**Application** H02-0866-25  
**Location** Land Rear of 75 South Street Crowland PE6 0AH  
**Proposal** Erection of Detached Single Storey Dwelling

**Name** Parish Clerk  
**Address** Crowland Parish Council

**Date Submitted** 23-10-25  
**For/Against** Comments

Site Layout 1:200 scale

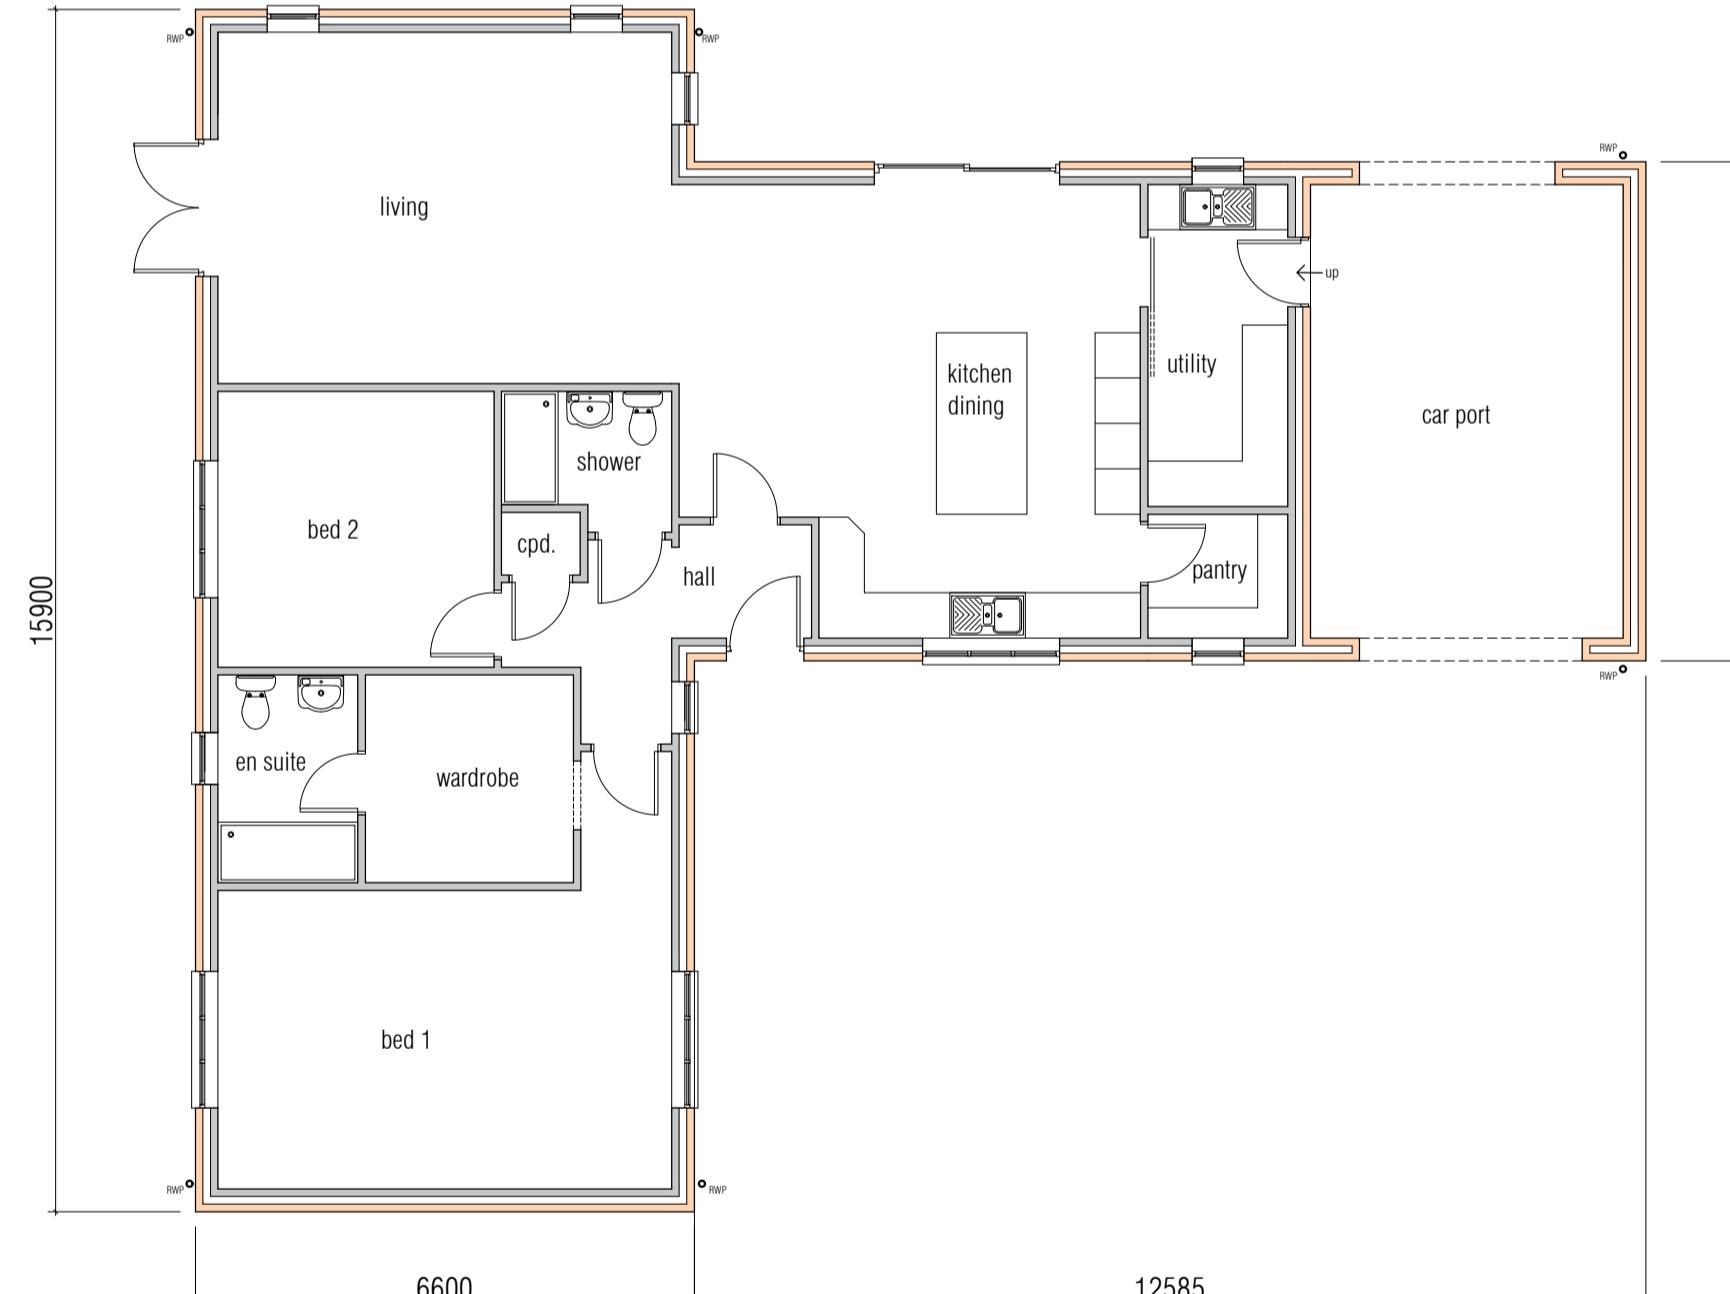
Access not suitable with the number of houses and concerns regarding the road structure and width of Hereward Way, otherwise no objections.
